TOWN AND COUNTRY PLANNING ACT 1990 WORKS TO A PRESERVED TREE

Reference: H02-0698-26 **Date of Decision:** 16th September 2026

Location: 6 Postland Road Crowland Spalding

Description: Works to Crowland Tree Preservation Order No 21 2018

Vehicle Tracking and Replacement Planting Plan

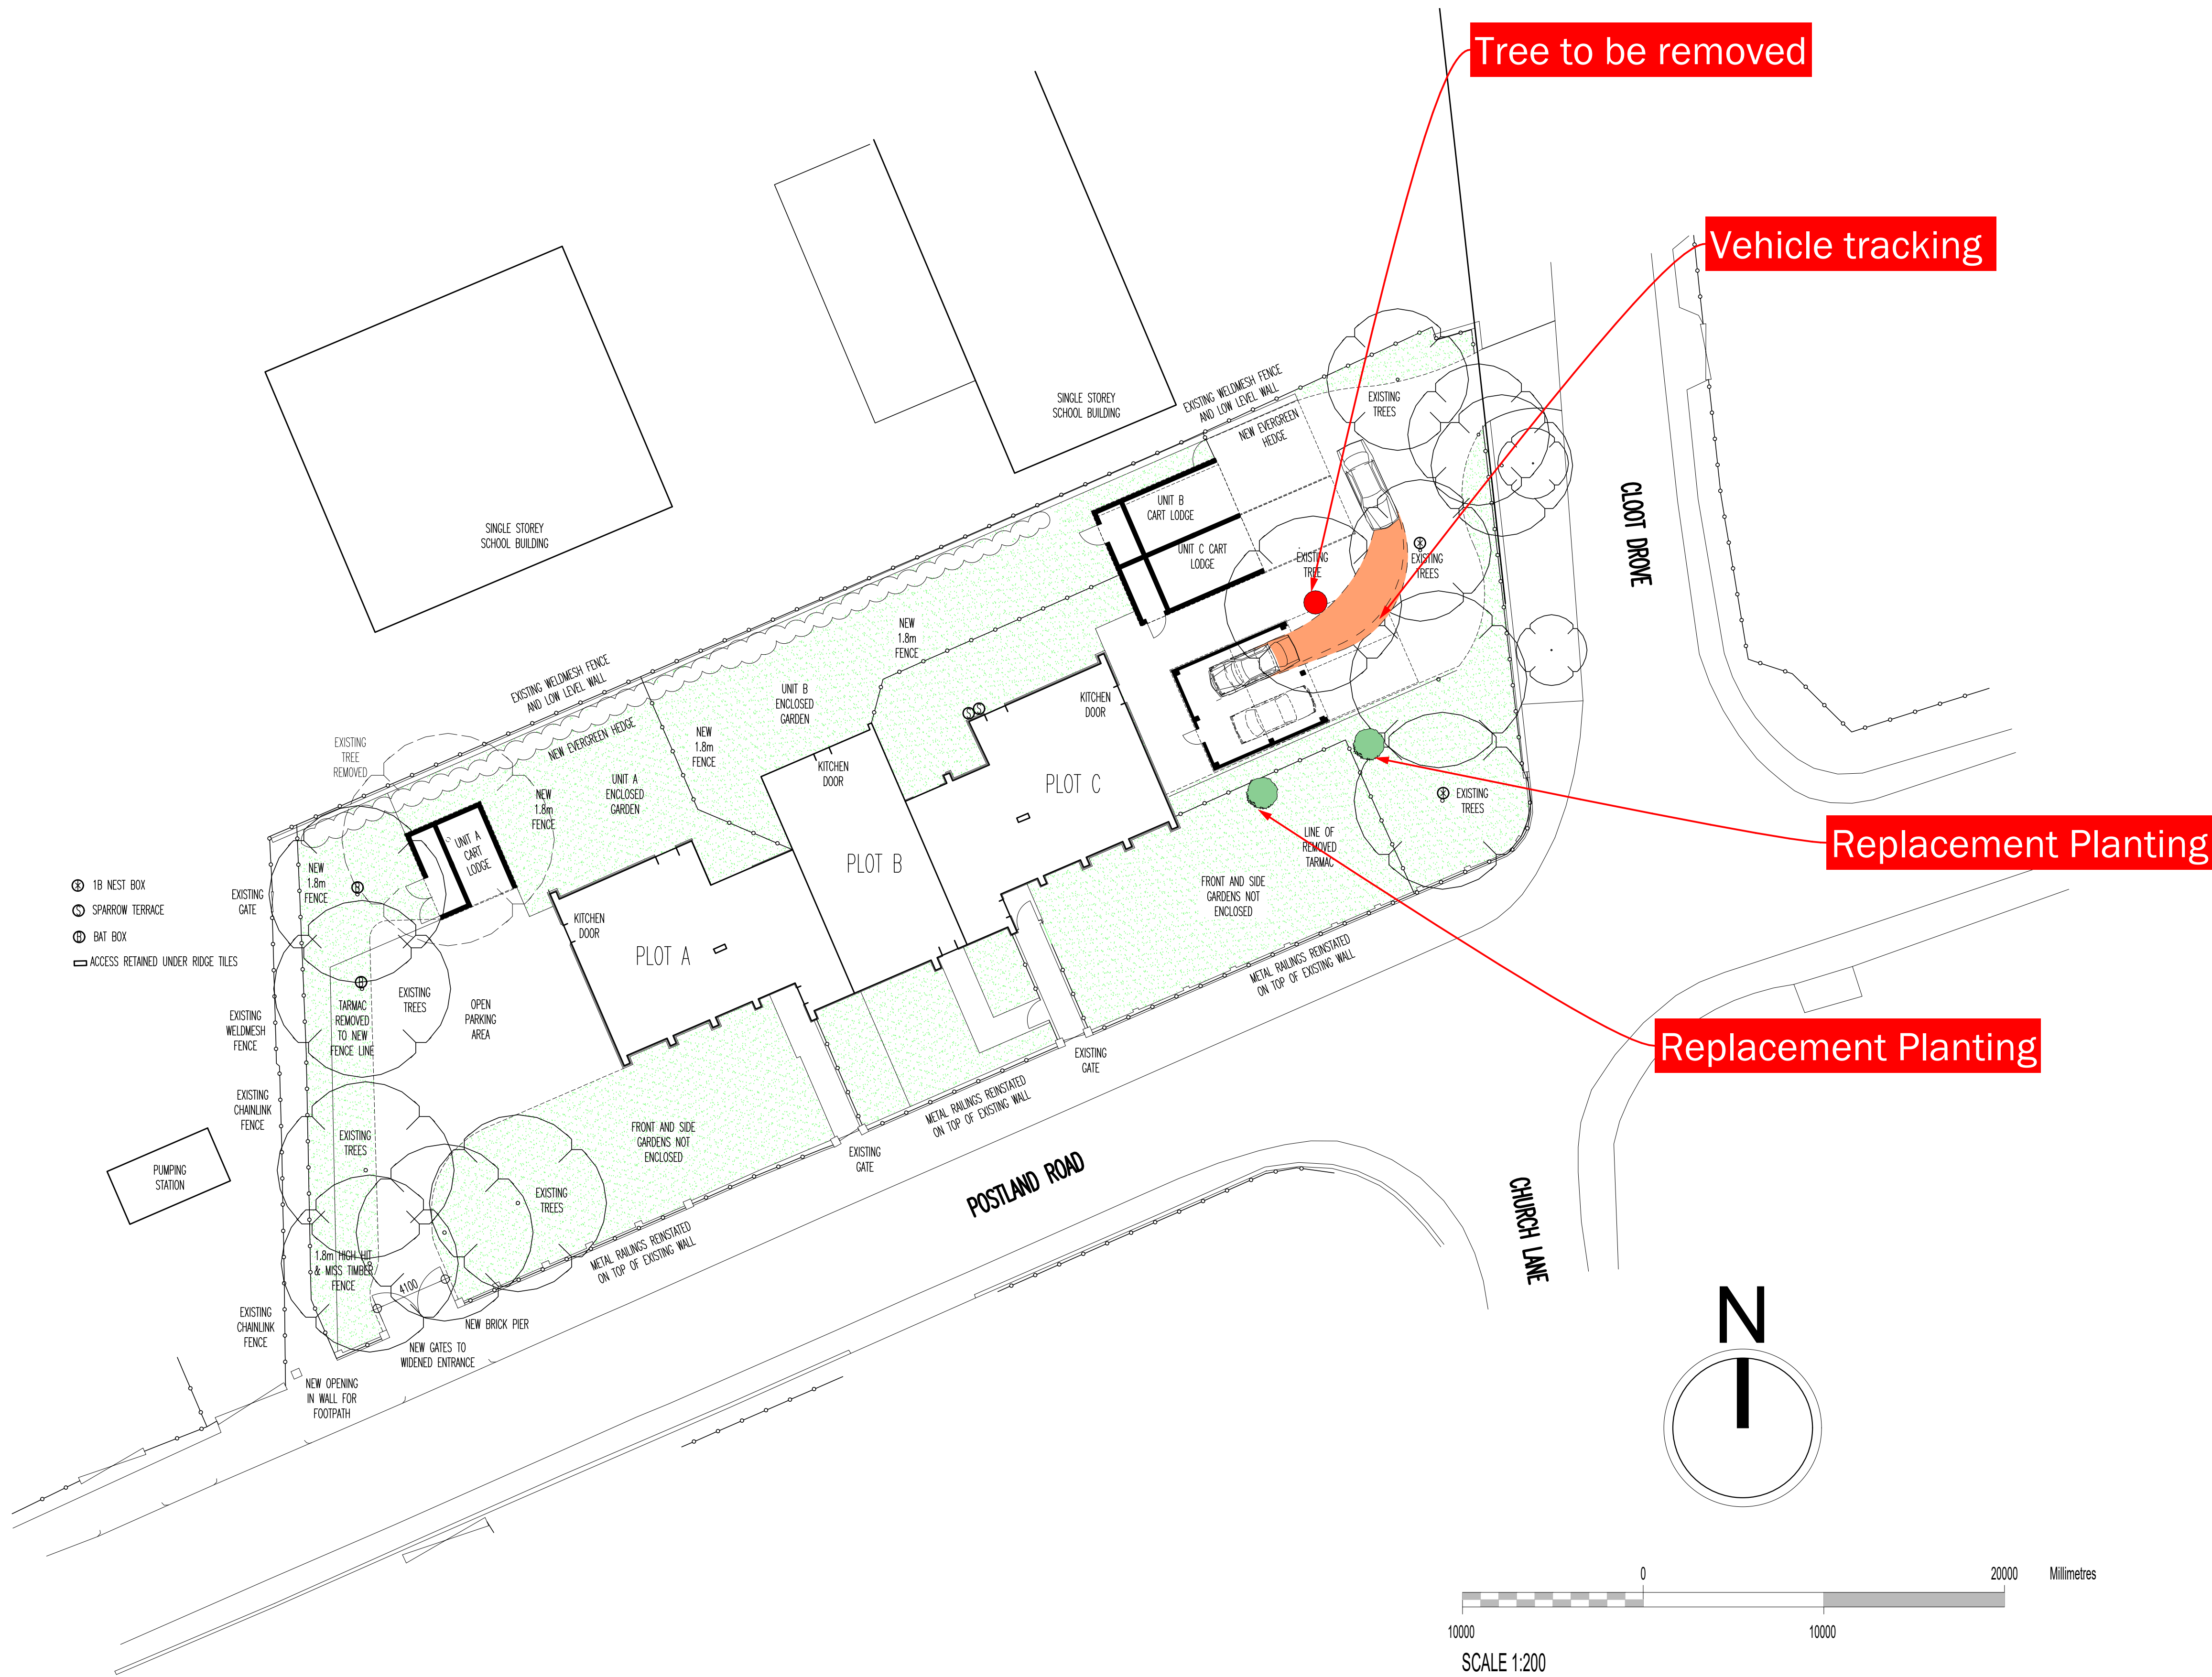
Application to remove a pollarded lime tree to facilitate the proposed use of a yet to be fully constructed garage which on the ground does not appear to be exactly located as approved on the plans.

- 4 The tree to be felled shall be replaced by two field maple of at least 1.5 metres high on planting within a period of twelve months from the date of felling. Replacements shall be planted within the frontage grass area forming part of the grounds of 6 Postland Road, approximately as indicated in Drawing AK0001 Rev A accompanying the Application. It would be advisable to plant the eastern most replacement so it can grow to maturity without conflict with the existing tree in the south eastern corner of the site, also giving consideration to the proximity of the frontage wall and building and any underground services.
